# DRIFTWOOD ESTATES FILING NO. 1

A SUBDIVISION IN THE NORTHEAST QUARTER OF THE NORTHEAST QUARTER OF SECTION 33, TOWNSHIP 11 SOUTH, RANGE 67 WEST OF THE 6TH P.M. EL PASO COUNTY, COLORADO

Pikes Peak Regional Building Dept / Enumerations Comment Remains Unaddressed.

# DRIFTWOOD ESTATES FILING NO. 1

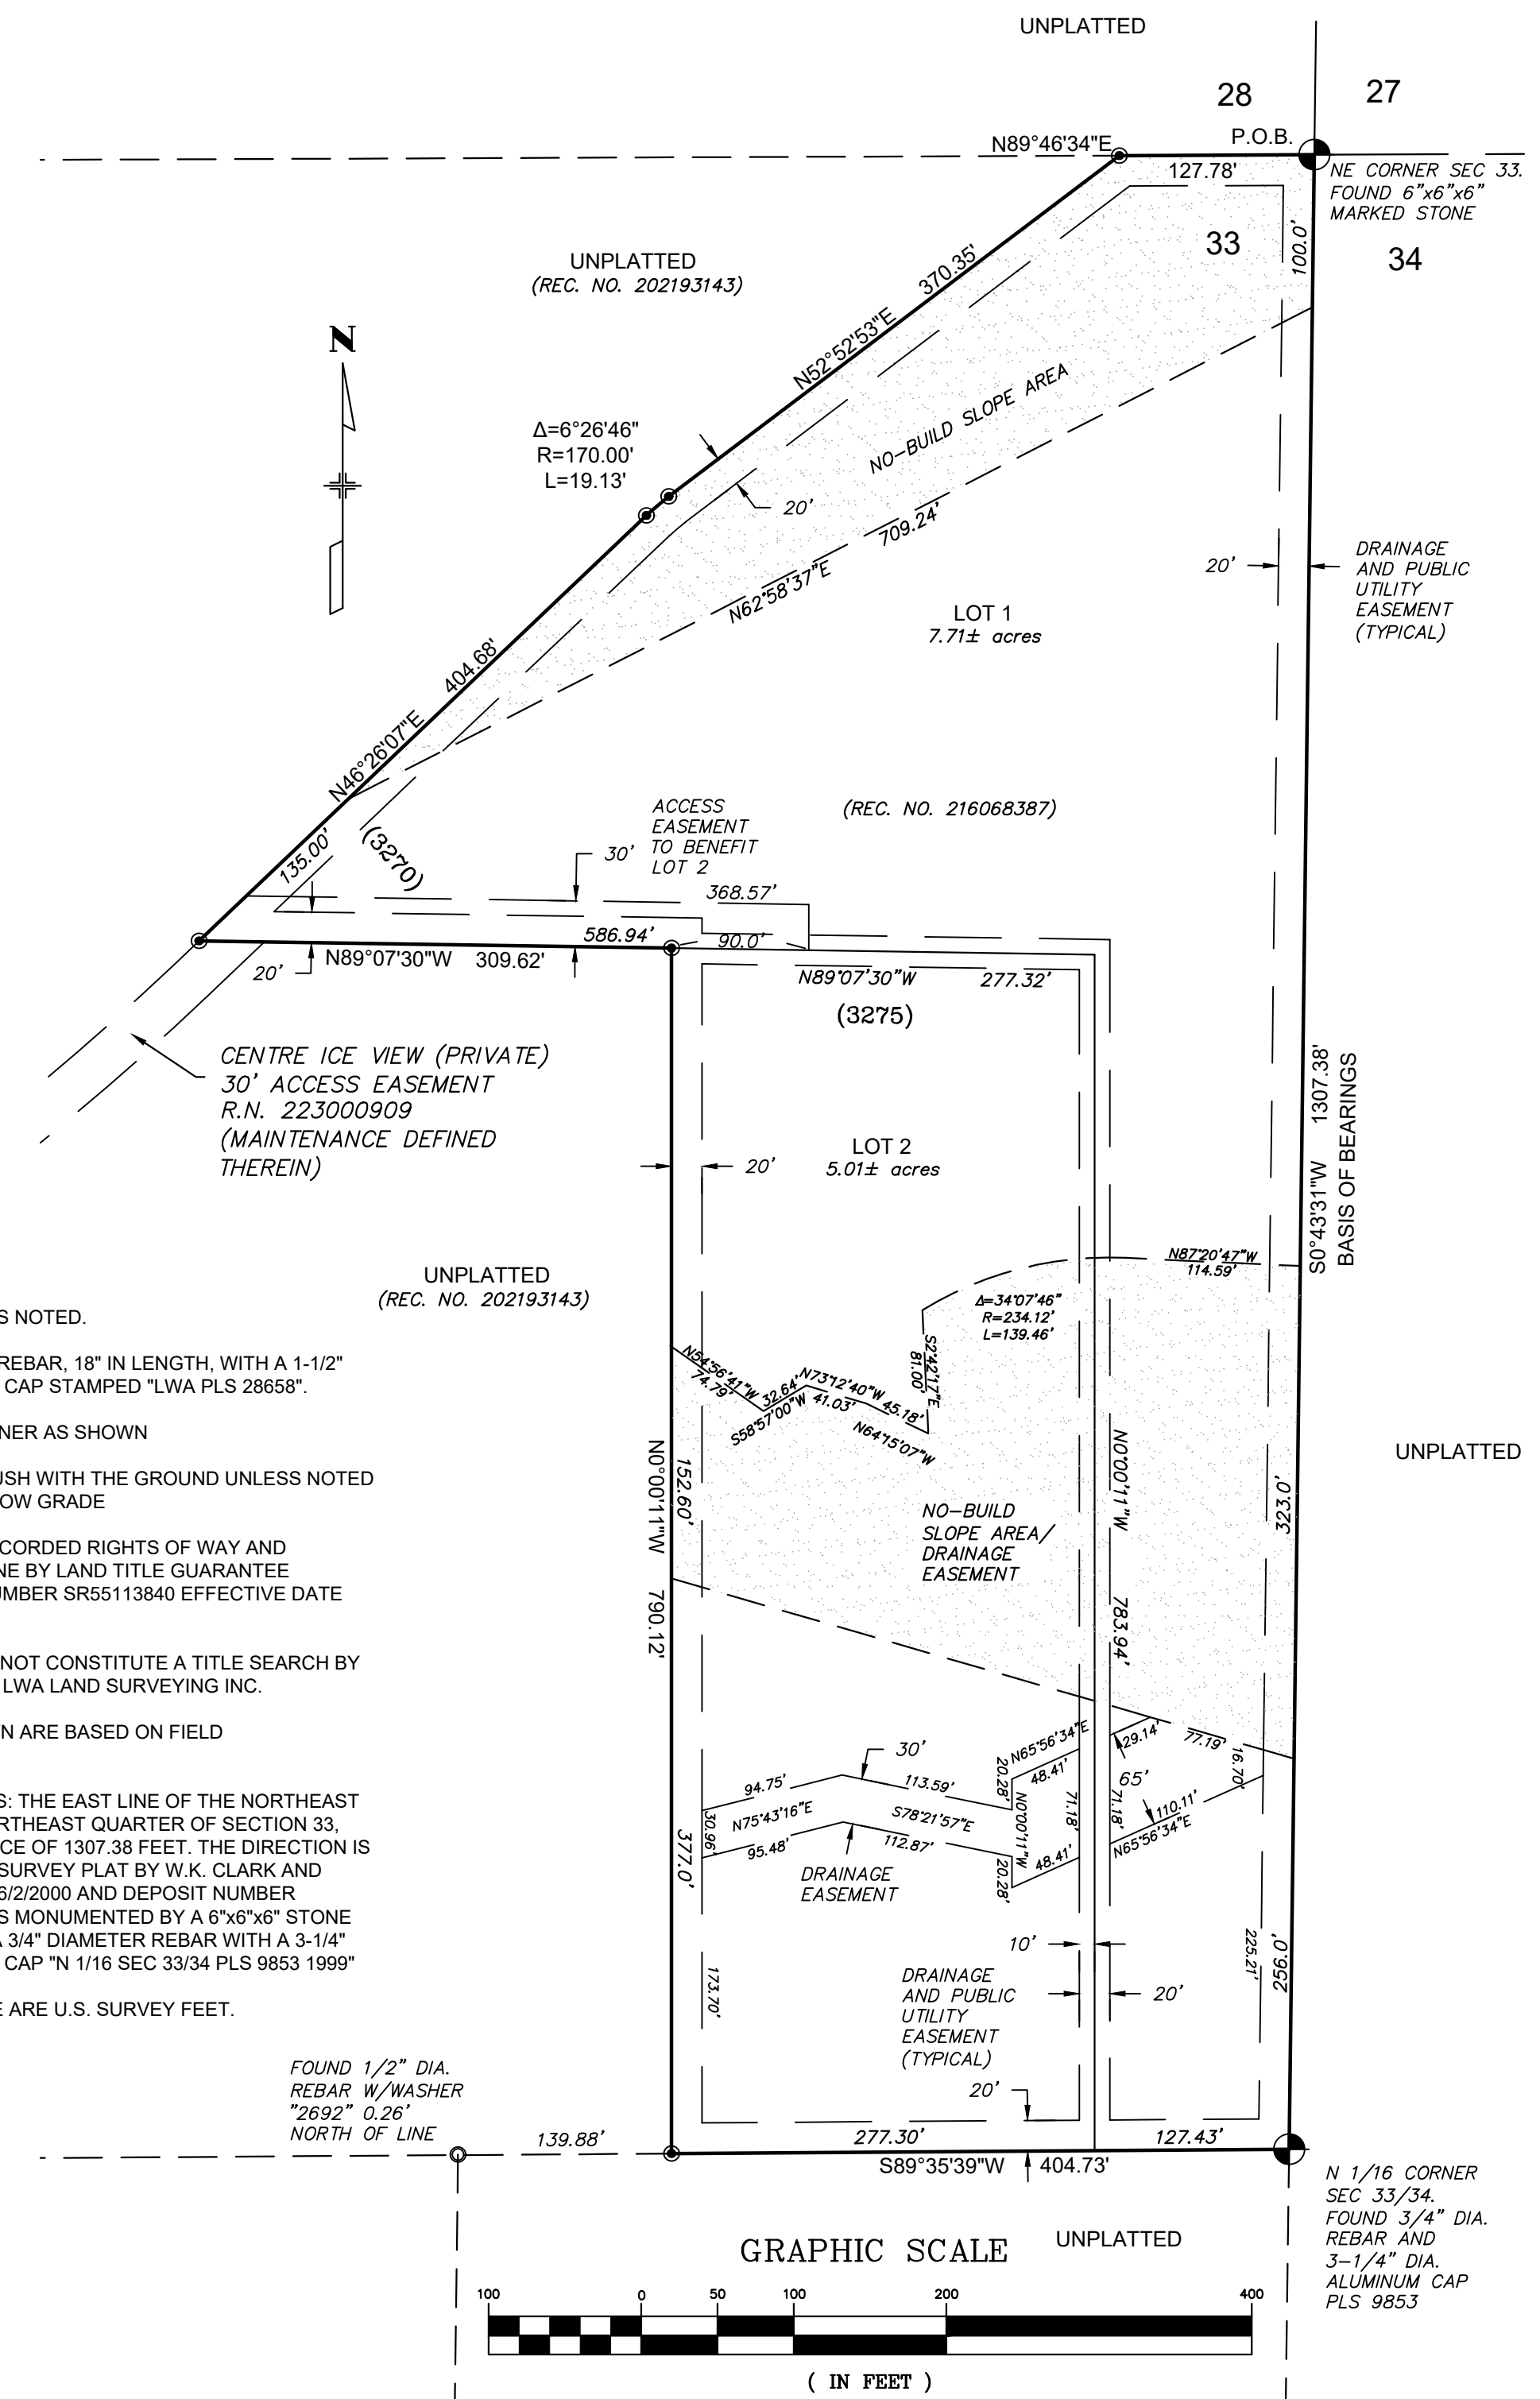
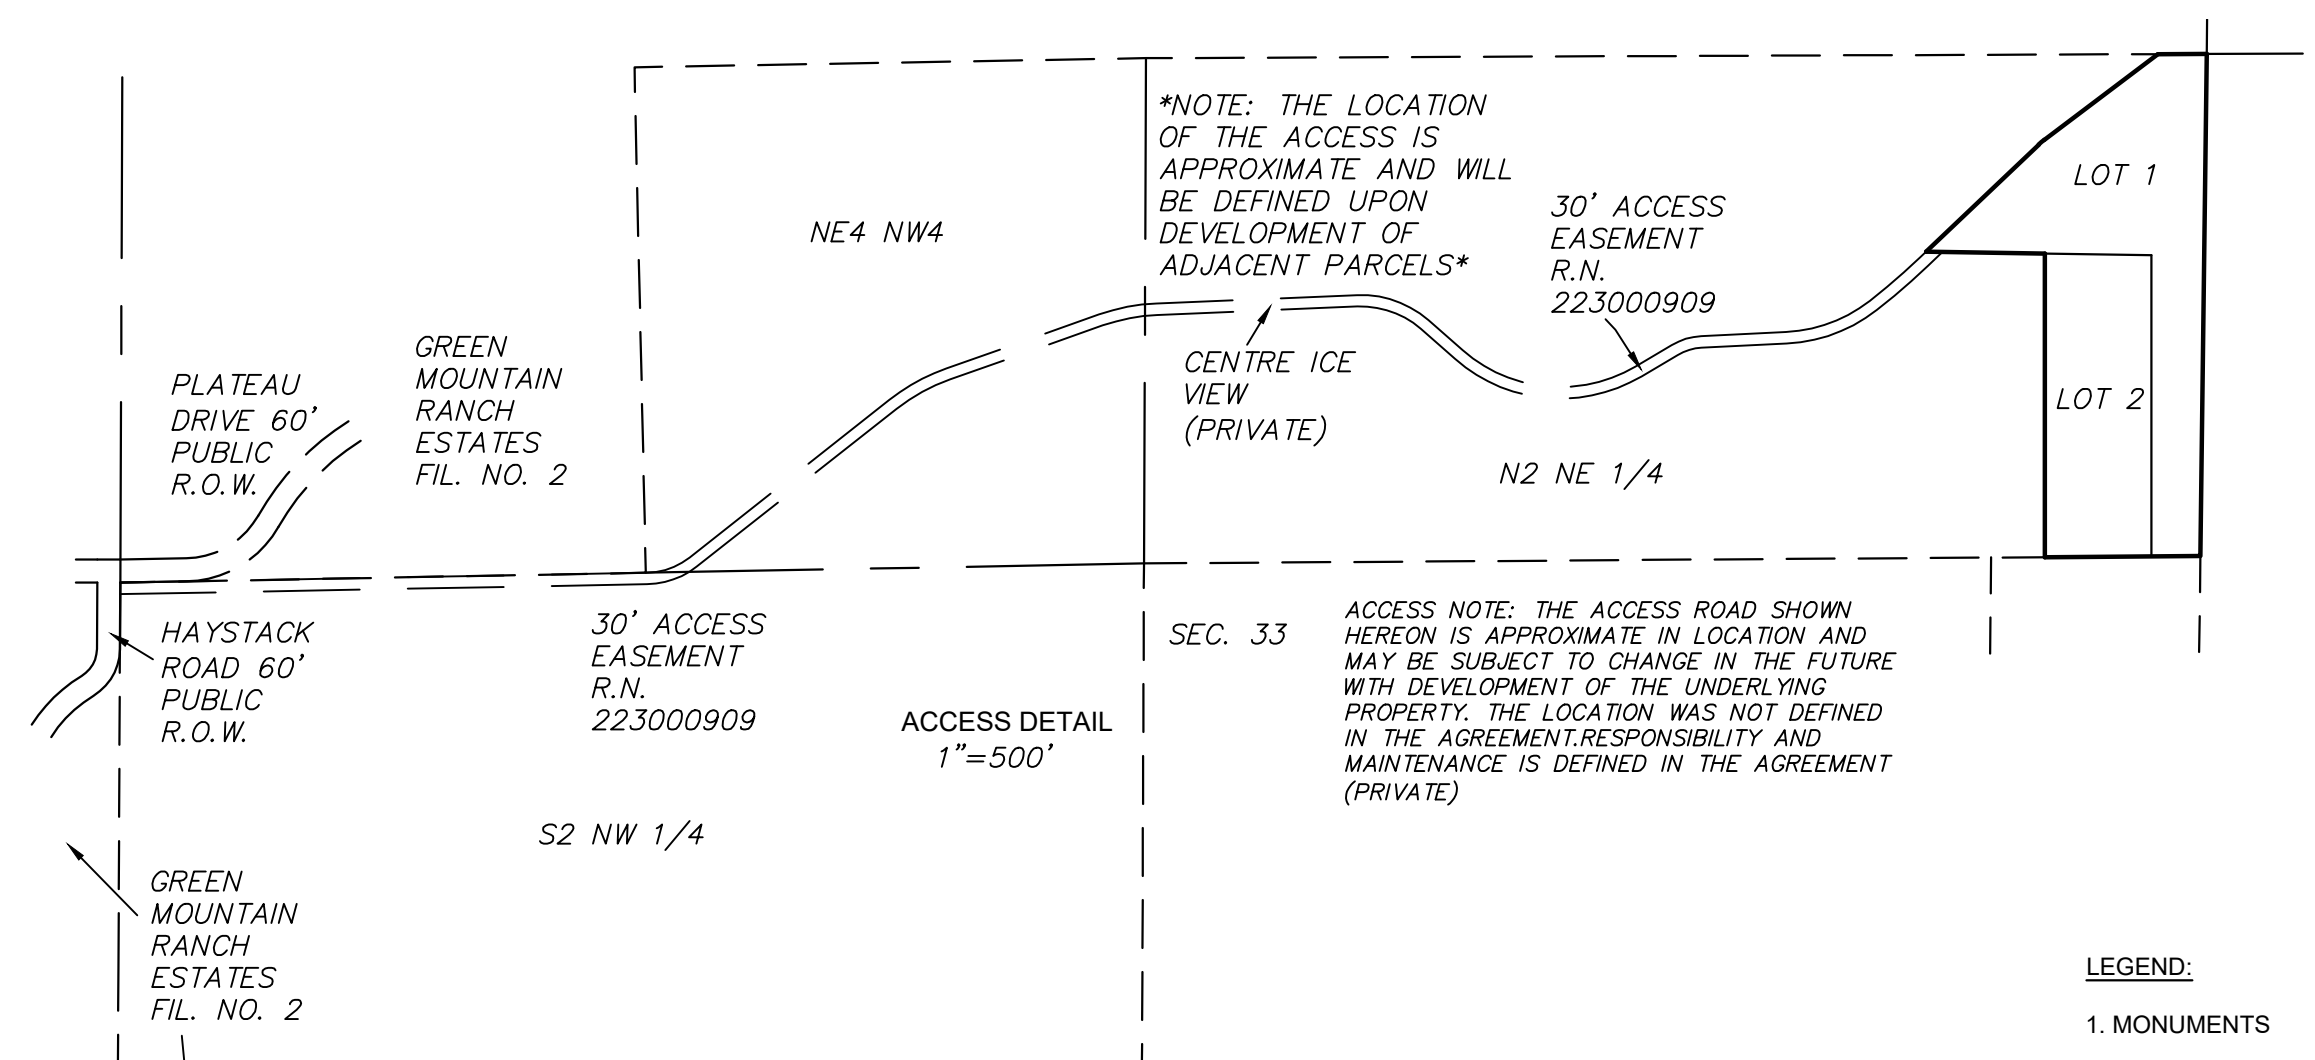
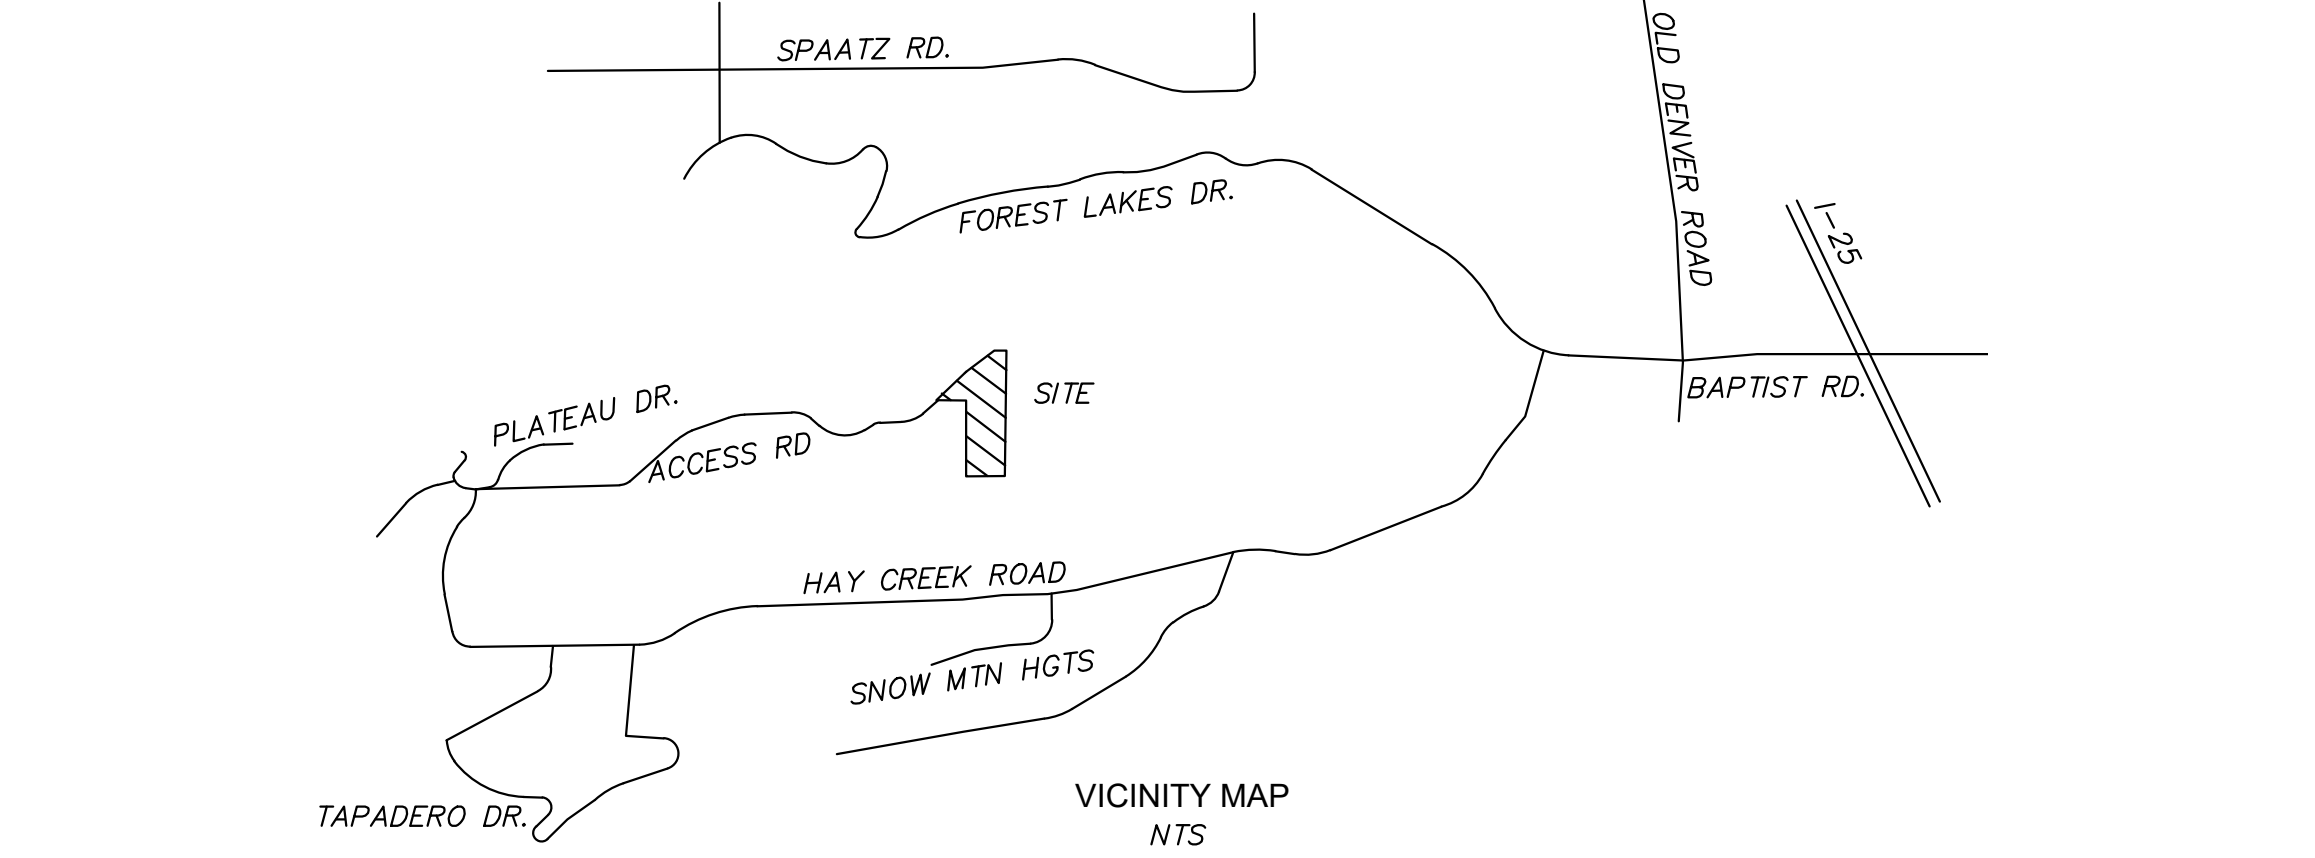
"The address of 3275 Center Ice View was previously assigned for the large parcel. Based on where the access is shown for the re-platted lots, Lot 2 should use the 3275 Center Ice View address, and Lot 1 should use the address of 3270 Center Ice View. These addresses need to be shown on the plat."
